WELWYN HATFIELD COUNCIL – DEVELOPMENT CONTROL
DELEGATED REPORT

| APPLICATION No: | S6/2009/2061/MA |

The application has applied for the retention of a chicken shed. The structure has been constructed with part brick, part timber walls with a sloping felt roof. The development measures 7.5m in width by 5.1m in depth with a mono-pitched roof to a maximum height of 2.7m.

Dwg No.
A3 0106/02

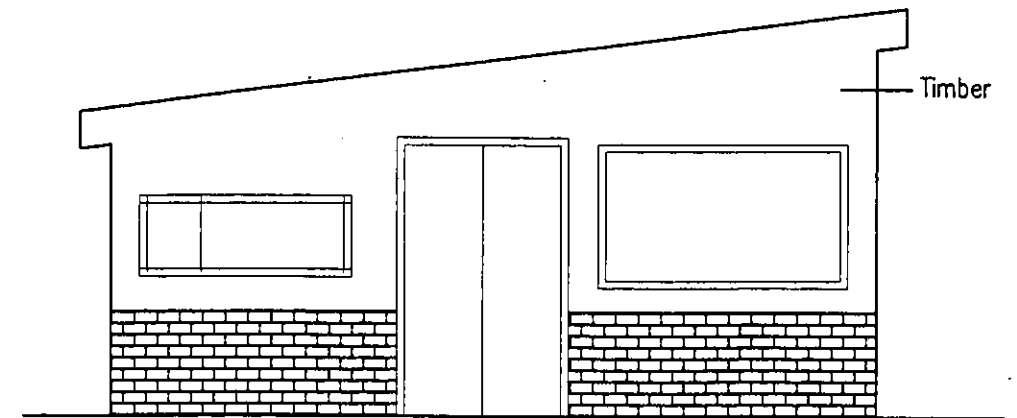
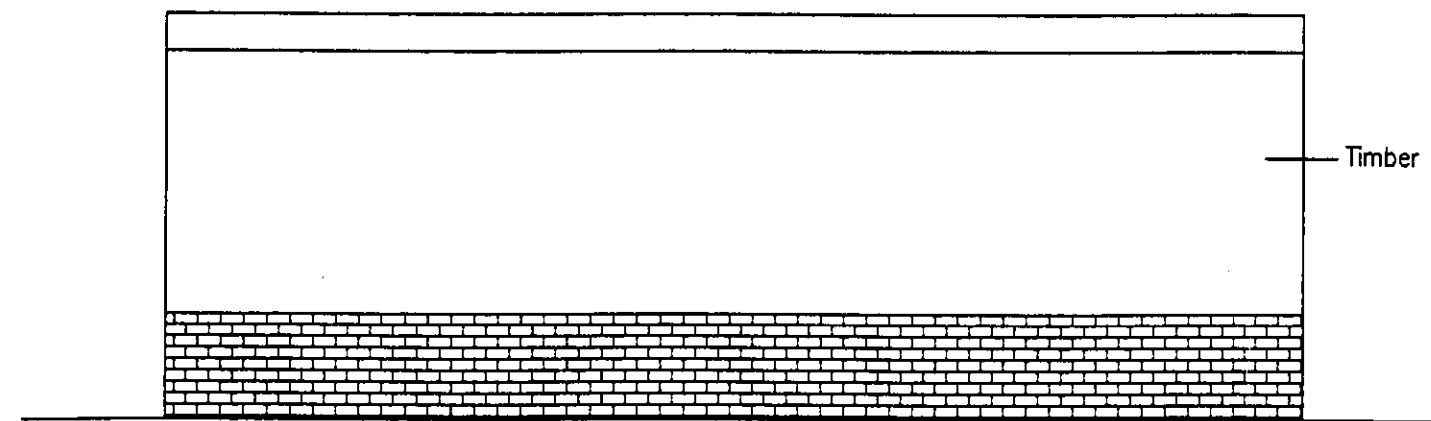
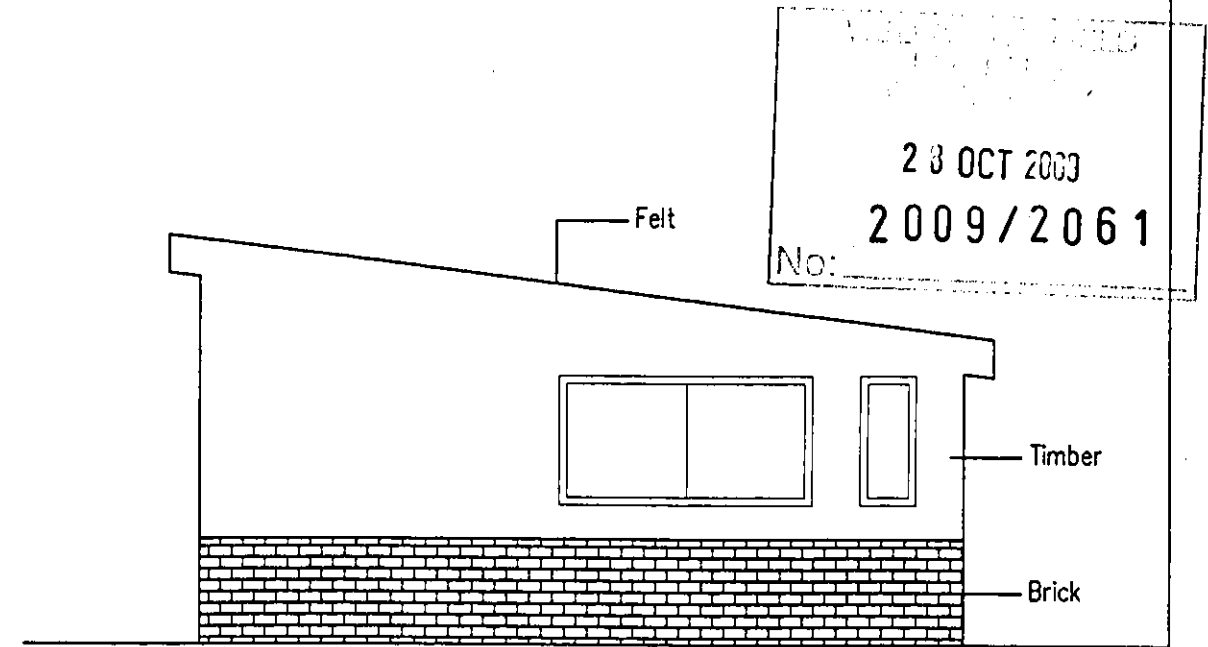
The structures have been placed on what previously would have been open Green Belt land. The development is noticeable and appears prominent, which is not in keeping with the rural and open character of the locality. The chicken shed is a large structure and from the adjacent footpath does not have an agricultural or rural appearance. Due to the untidy and developed appearance of the site, it appears urbanised and unattractive from the surroundings. The appearance of the site is worsened by the adjacent fencing, palisade gates and various items that are stored on open land.

The chicken shed and other additions to the site do not have an acceptable quality of design and affect the character and appearance of the locality. Therefore, the development fails to meet the requirements of Policies D1 and D2 of the Welwyn Hatfield District Plan 2005.
